# memorandum

date April 3, 2017

subject Proposed NFH Single Family Residence (CA016-002) – Environmental Review

Critical Area Study and Mitigation Plan Maps  
(Existing Conditions, Proposed Ecological Improvements)

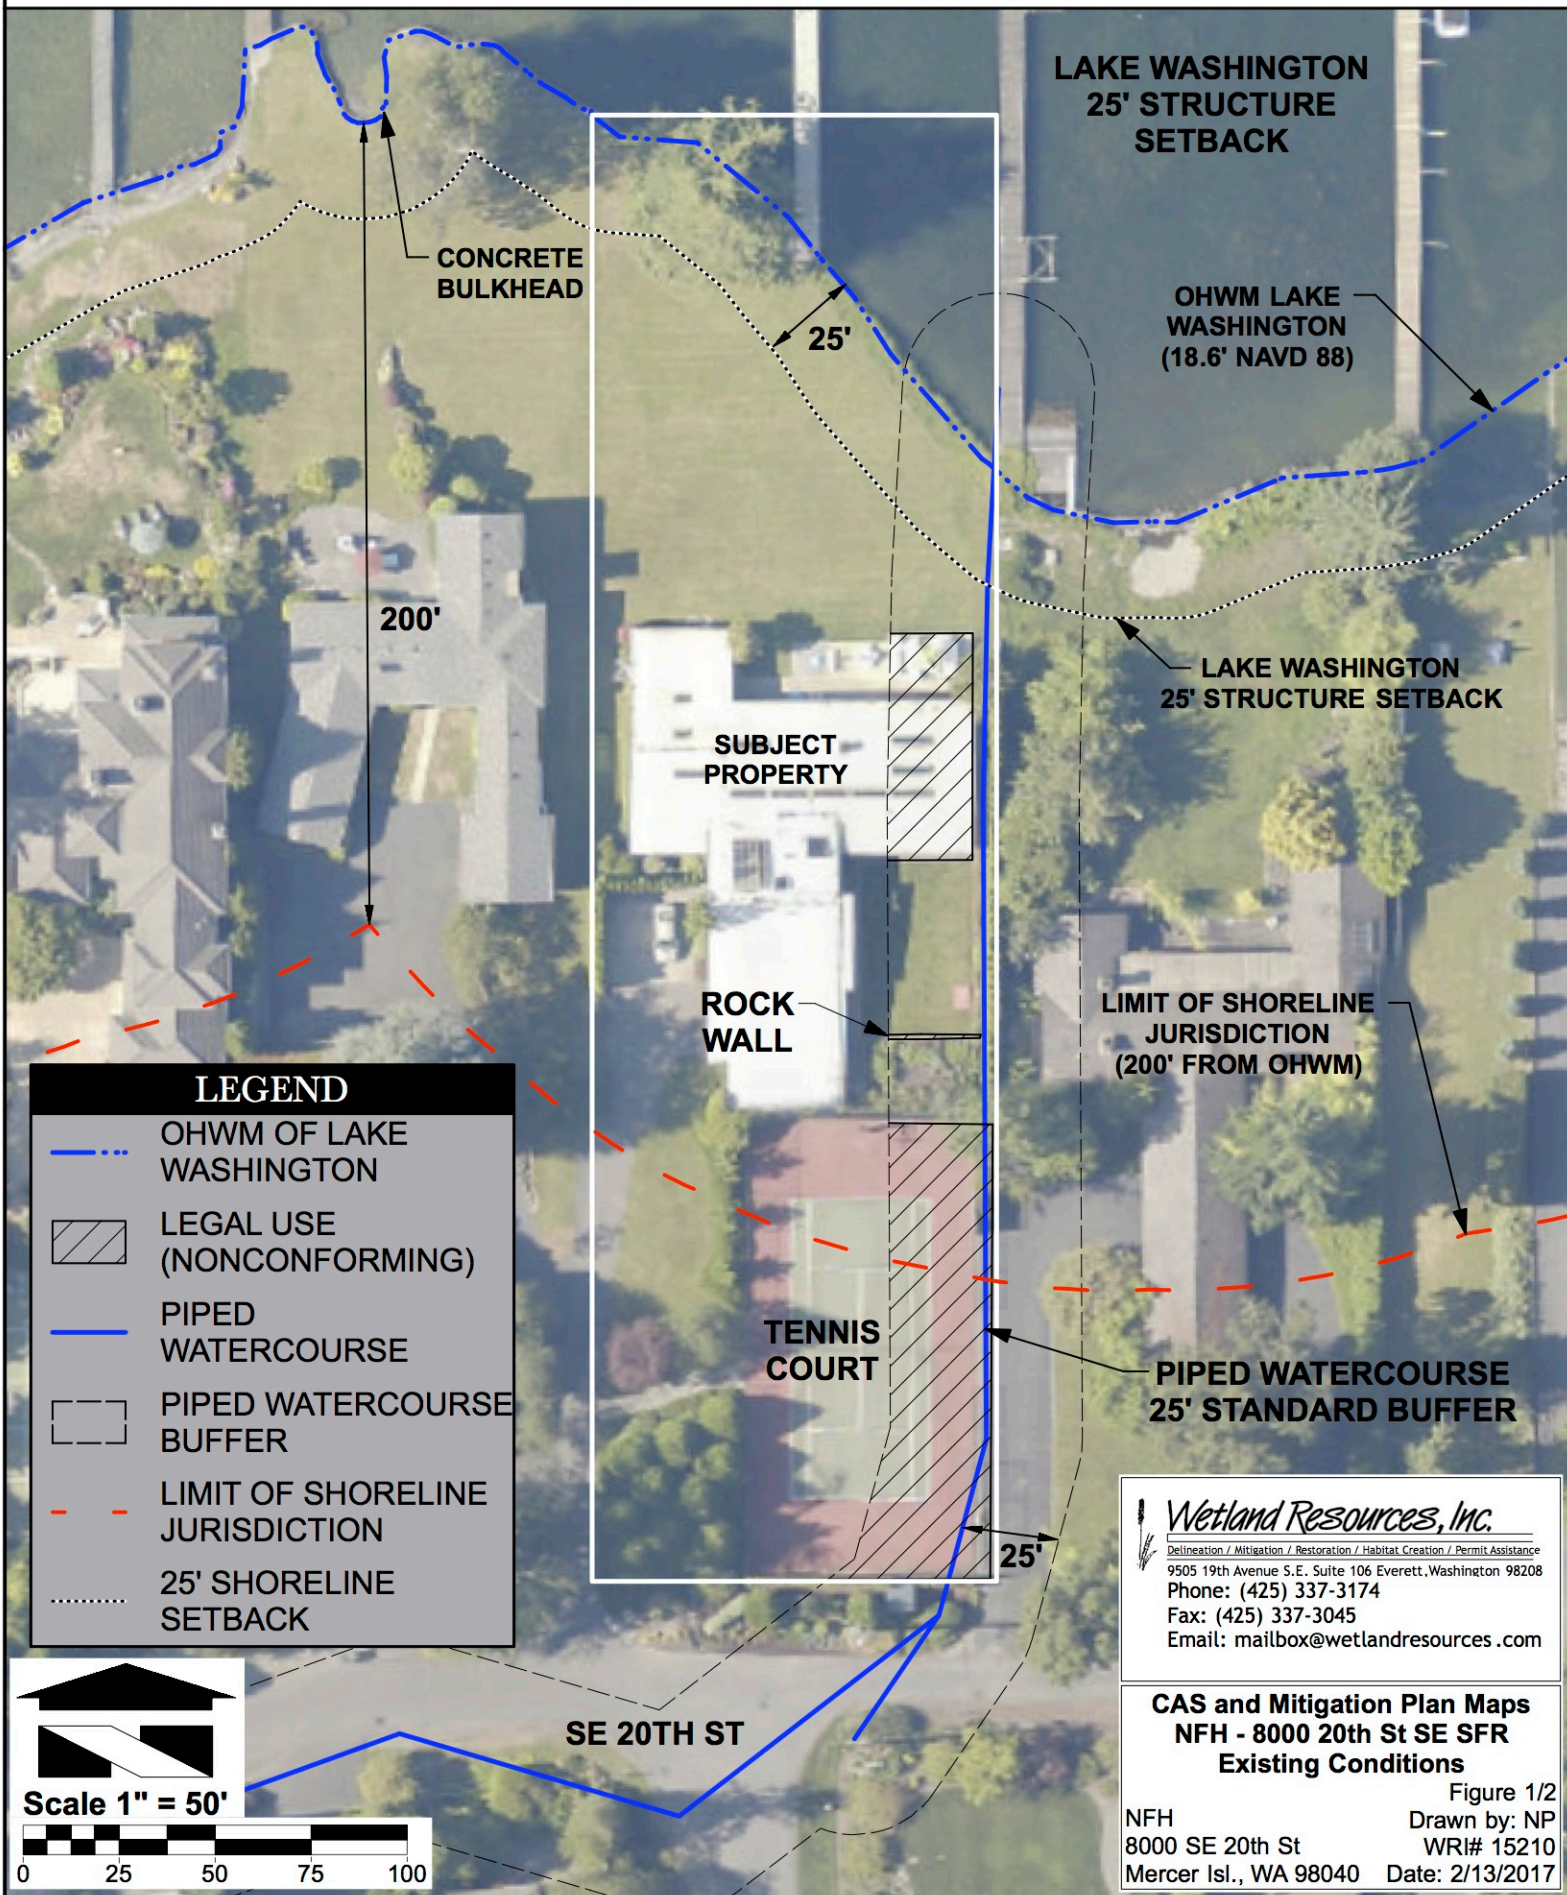
The Mitigation Plan Map included as the final page of the CAS & Mitigation Plan shows all proposed enhancements, at a conceptual level, to meet City requirements (MICC Chapter 19.07). Mitigation for reduction of the piped stream buffer from 25 feet to zero feet now includes proposed bulkhead removal and beach restoration. Concrete / rockery bulkhead removal will occur on the subject property (14 linear feet) and on the adjoining property to the west (75 linear feet). In total, bulkhead removal and proposed shoreline restoration will result in 570 square feet of new sandy beach along the Lake Washington shoreline. Shoreline restoration will be provided along with a green roof on the new residence, and use of pervious pavement, as well as installation of native plants between 0 and 20 feet from OHWM of Lake Washington. Shoreline plantings in this area are required by the SMP (MICC 19.07.110) to mitigate the increase in footprint of the new home.

We generally agree that this conceptual approach will provide sufficient additional mitigation consistent with MICC 19.070.070.B.2.b. While the approach will not result in direct enhancement to the piped stream, we believe that the proposed bulkhead removal and beach restoration along the Lake Washington shoreline will provide a similar functional benefit compared to daylighting the downstream-most portion of the piped stream. In either case, the primary functional improvement would be to habitat available for juvenile salmon and other wildlife using the lake shoreline. In fact, proposed restoration of the shoreline will likely provide higher habitat functions than would be provided by daylighting of a small segment of the piped watercourse.

### PROPOSED ECOLOGICAL IMPROVEMENTS

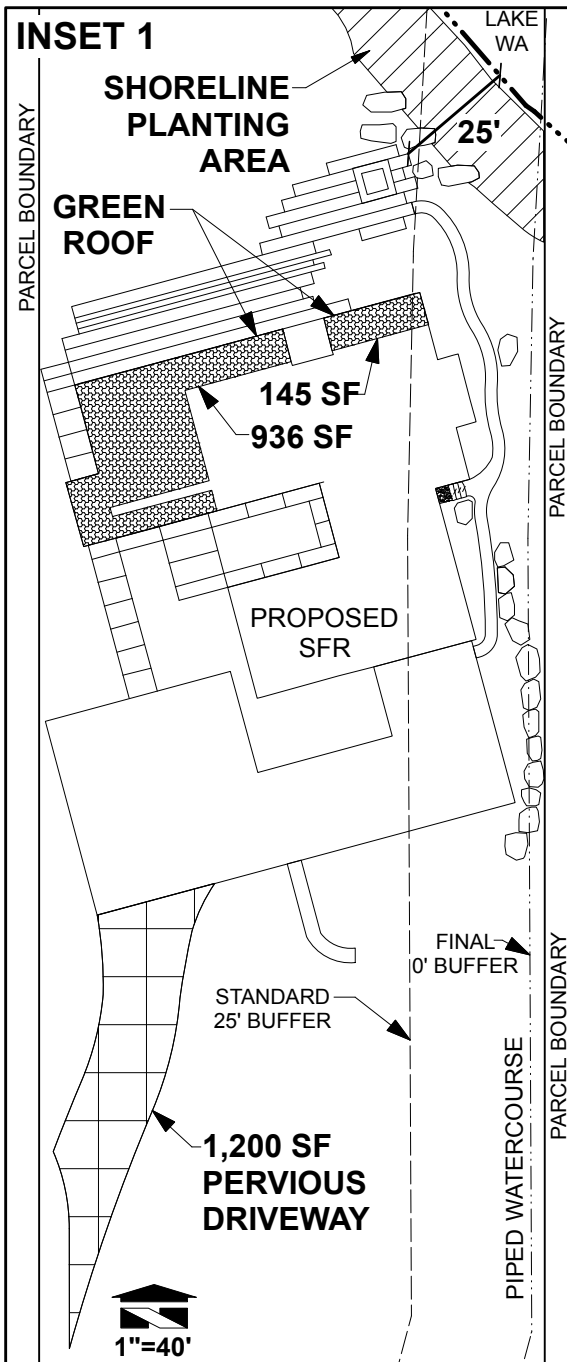
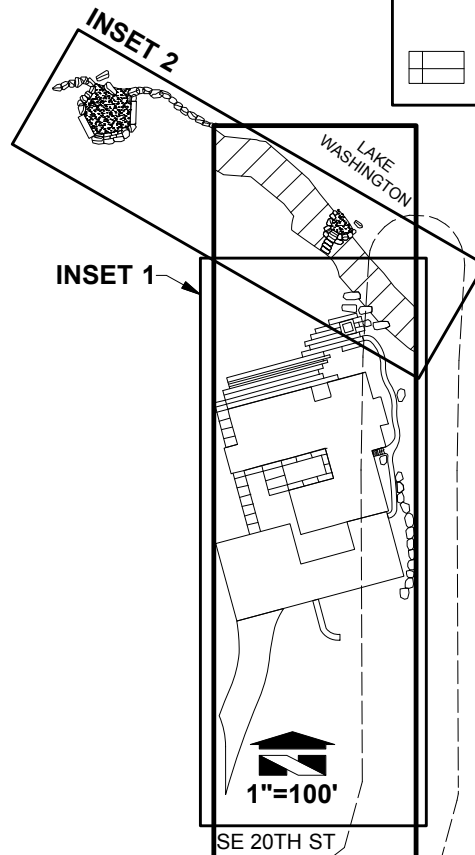
We do recognize that the City's intent of maintaining a buffer around piped streams is to allow for future daylighting. Given this intent, we recommend that the applicant consider opportunities to provide a 5-foot minimum buffer (free from new fill and structures) to the west of the on-site piped stream alignment. At minimum, this should include realignment of the proposed rockery and southeast corner of the proposed motor court, or consideration of an alternative structure or design approach in this area of the site.

- The areas established as sandy beaches should include analysis of the slope that will be created, with assurance that the slope is as close to 7:1 as possible (and not steeper than a 4:1 slope).

- Emergent aquatic plantings intended to stabilize the shoreline from wave erosion should be included in the design for the established sandy beach areas. Appropriate native shrub and tree plantings (potentially including willow and dogwood livenstakes and/or fascines) and large wood (logs) should be considered for use in the rockery / large stone placement design.

- The final Mitigation Plan / Landscaping Plan should specify plant species, quantities, spacing, and planting details for the shoreline planting area and the bulkhead removal / shoreline restoration areas.

With modifications to the site plans that achieve a minimum 5-foot corridor to the west of the piped stream, and with implementation of recommendations for the final Mitigation Plan / Landscape Plan, we agree that the proposal is consistent with the requirements of MICC Chapter 19.07. If you have any questions, please call me at (206) 789-9658.

**MITIGATION &
RESTORATION
PLAN**

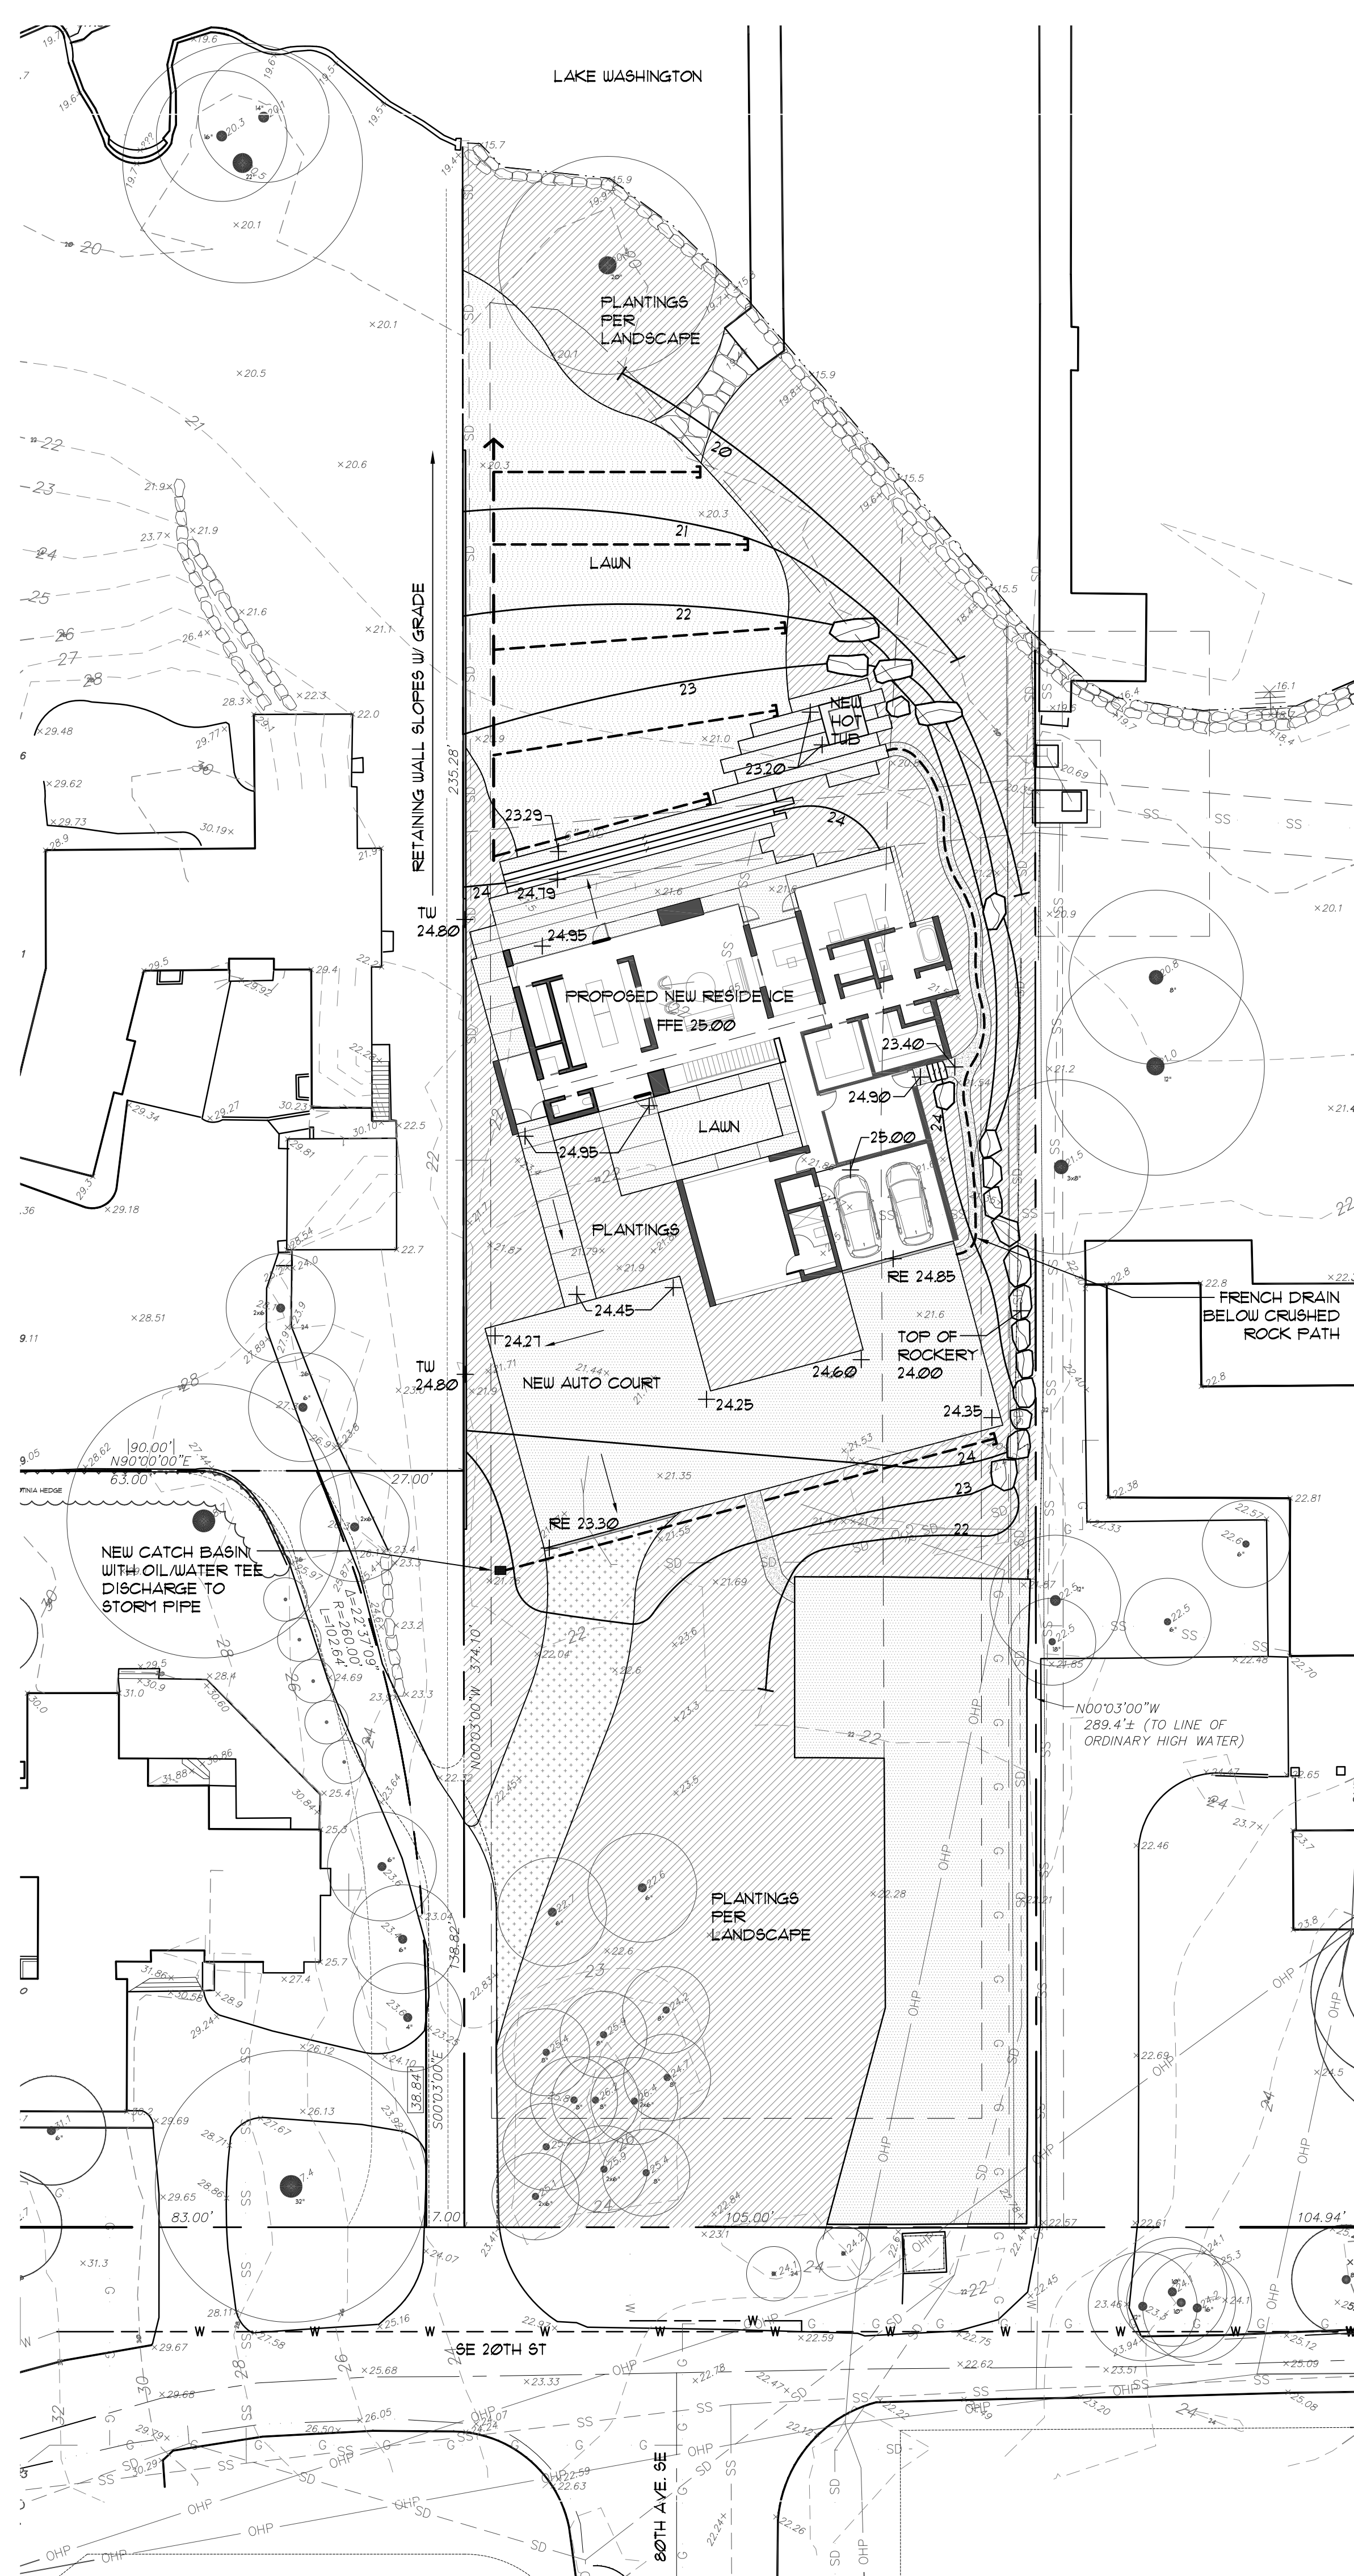
- Plans for bulkhead removal and shoreline restoration should include specifications on construction BMPs, materials, and placement intended to minimize any short term impact to Lake Washington and maximize the long-term success of the enhancement. The City should ensure that the applicant has received all necessary permits and approvals from the U.S. Army Corps of Engineers and the Washington Department of Fish and Wildlife, including seasonal limits for in-water work to protect fish.

- The final Mitigation Plan / Landscaping Plan should include specifications for invasive species removal (English ivy currently growing along the shoreline, including over the bulkhead, and other invasive) during initial and final installation.

- The final Mitigation Plan / Landscaping Plan should include performance standards for the bulkhead removal / shoreline restoration area (as well as the shoreline planting area), including a 100% survival standard for year one, and percent cover standards for native plants (and for control of invasive species) in subsequent years. Annual assessment of the beach area extent should be included as a performance standard, with potential adaptive management strategies listed if monitoring shows that the new sand beach areas are eroding.
- The final Mitigation Plan / Landscaping Plan should include specifications for maintenance and monitoring through a five-year period, assuring that performance standards are achieved.
